Case Officer: Gemma Magnuson **Recommendation:** Approve

Applicant: Mr & Mrs A Pasteur

Proposal: Amendments to the external elevational treatments to the potting shed/garden studio design as previously permitted under 19/00532/LB

rev.	description	date	dm	ckd
	project			
	Cedar Lodge, North Side			
	Steeple Aston OX25 3SE			
	site			
	Works to Potting Shed to form home office			
	first issue	06.06.2019	checked	djs
	scale	1:50@ A3	drawn	TW
	dep. no.			
	2018-1014-GA11			
				B

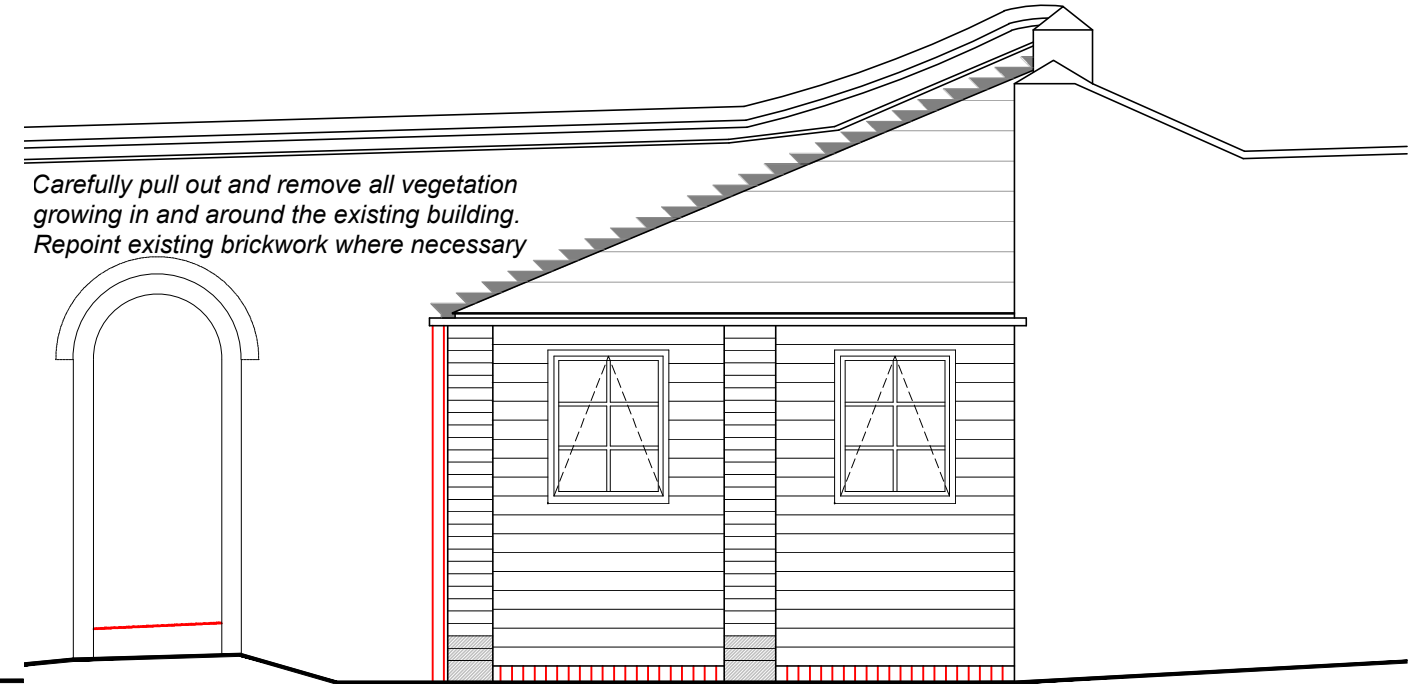
- 6.4. CDC Conservation - There are no particular objections to the alternative external appearance of the potting shed. There are some concerns that the proposal is to replicate the design / profiles of the kitchen extension as the potting shed is clearly historically distinct from the principal property. It was understood from a site visit to the property that a more significant level of work was required to the historic fabric due to defects that were uncovered during the commencement of works. This was clearly necessary (particularly in terms of the rebuild of the brick piers), but should be detailed in a schedule of works or method statement. A core consideration will be the impact on the historic boundary wall and further information / justification is required about the insulated plasterboard to ensure it will not be causing environment damage to the historic fabric and will allow the wall to breathe.

- 8.7. The use of timber cladding upon an outbuilding is considered acceptable, and whilst there are concerns regarding the domestic appearance of the garden studio, given the physical separation of the structure from the main dwelling I do not consider that this could be described as causing harm to the historic significance of the listed buildings or their setting.

3. Prior to the erection of the walls of the outbuilding hereby approved, opening details at a scale of 1:20 including cross sections shall be submitted to, and samples of the proposed construction materials shall be made available for inspection on site, and approved in writing by the Local Planning Authority. The development shall be carried out in accordance with the approved details and retained as such thereafter.

rev.	description	date	dm	ckd
project Cedar Lodge, North Side Steeple Aston OX25 3SE				
site Works to Potting Shed to form home office				
first issue	06.06.2019	checked	djs	
scale	1:50@ A3	drawn	TW	
dep. no.				
2018-1014-GA10				B

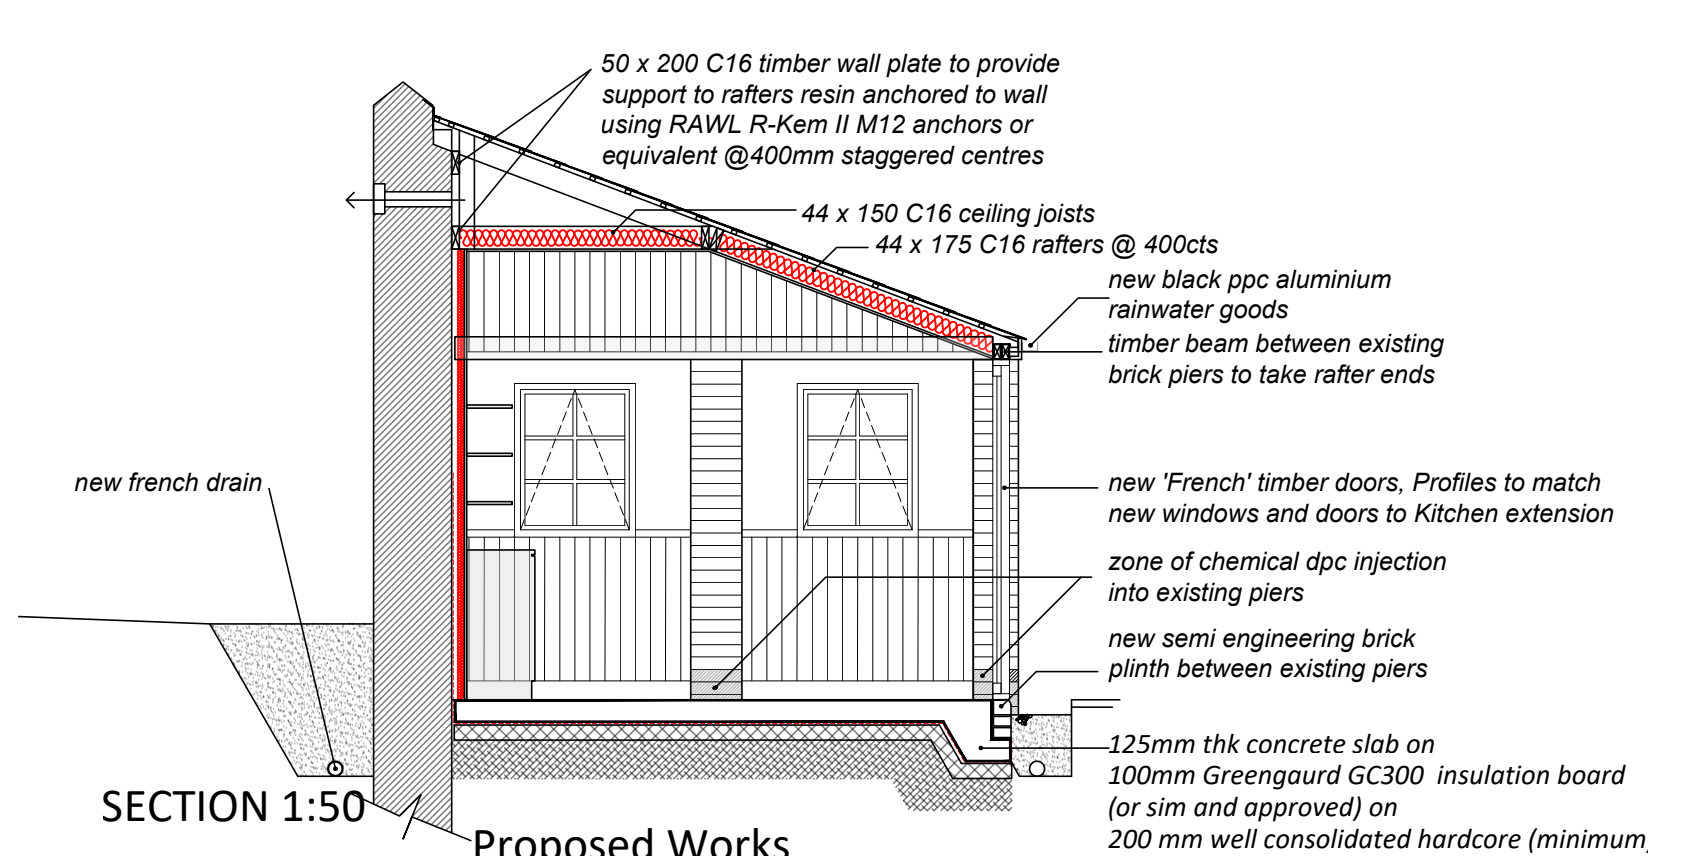
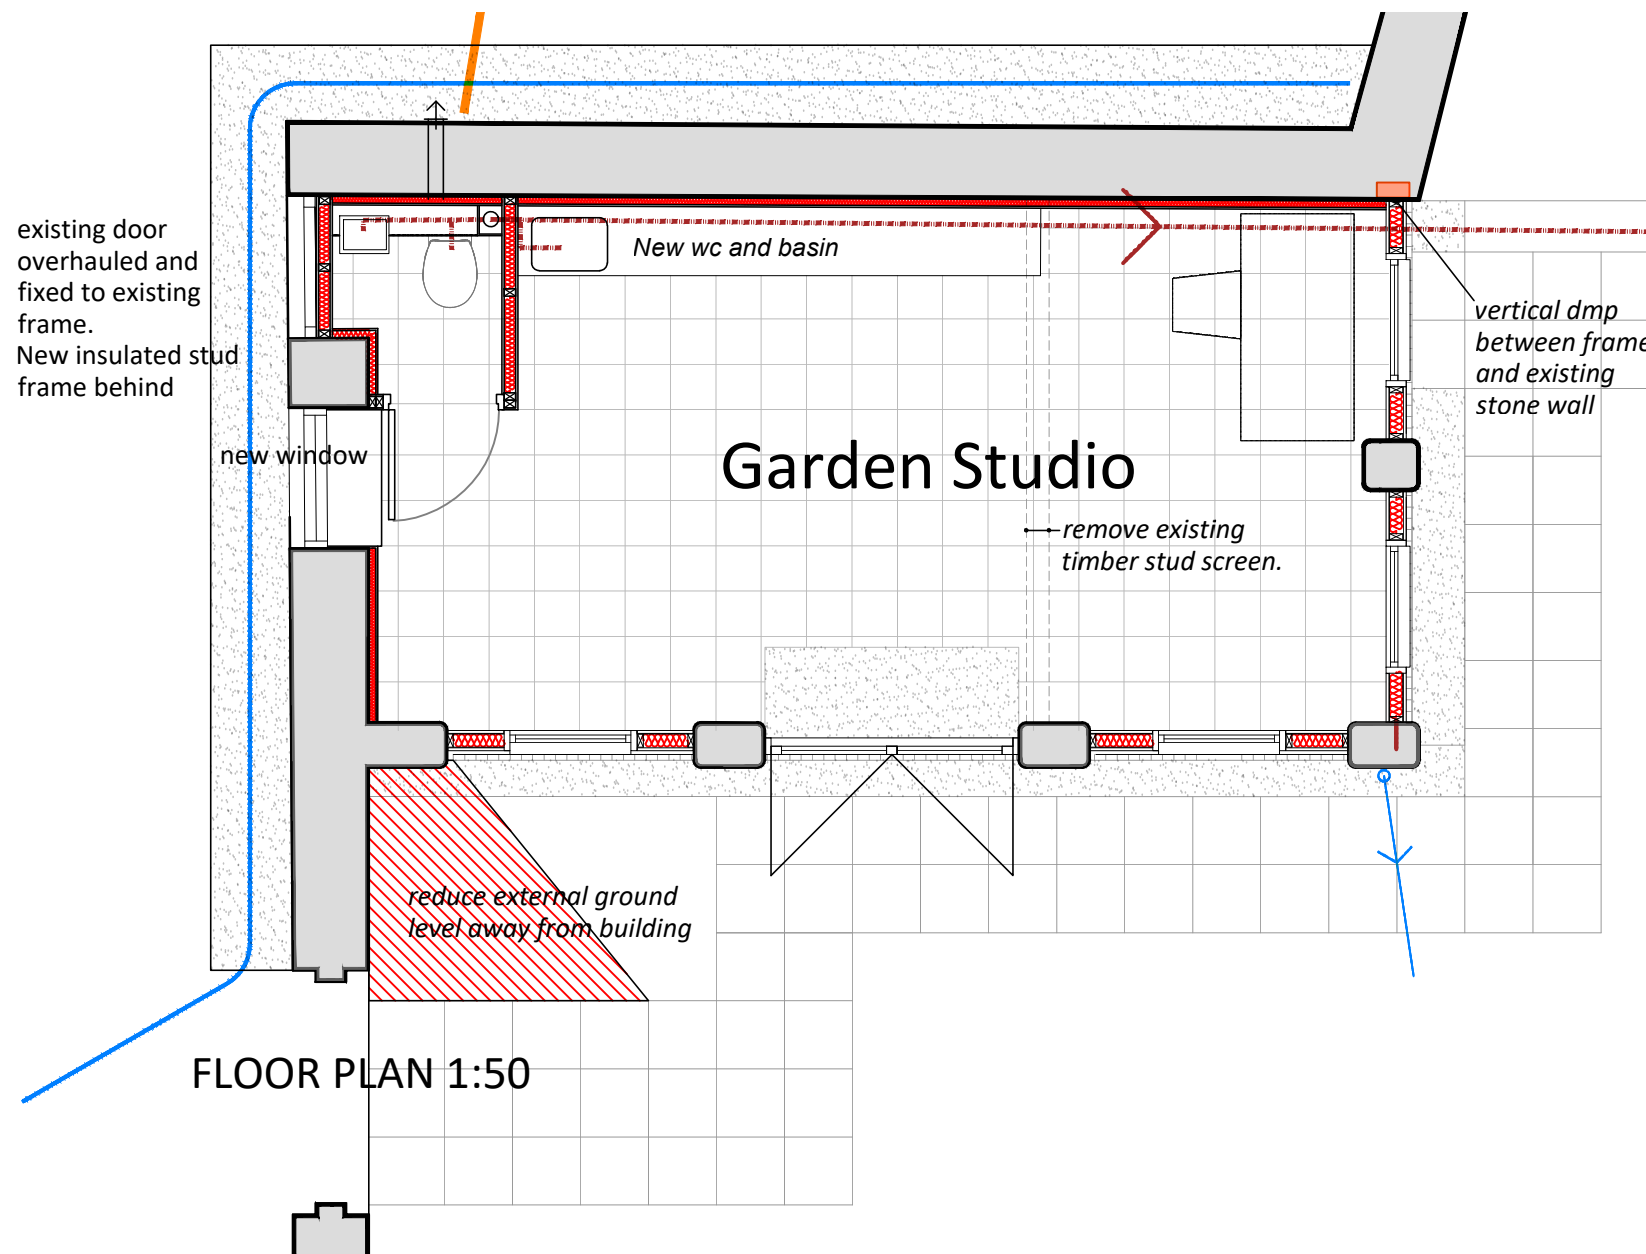
- 8.8. The Conservation Officer has requested further details of the rebuilding of the piers and insulation, and I have therefore recommended conditions. The proposal accords with the above Policies.

4. Prior to the restoration/reconstruction of the brick piers, a method statement detailing how the work would be undertaken shall be submitted to and approved in writing by the Local Planning Authority. The development shall be carried out in accordance with the approved details.

5. Prior to the installation of any insulation adjacent to the existing stone wall, full details shall be submitted to and approved in writing by the Local Planning Authority. The development shall be carried out in accordance with the approved details.
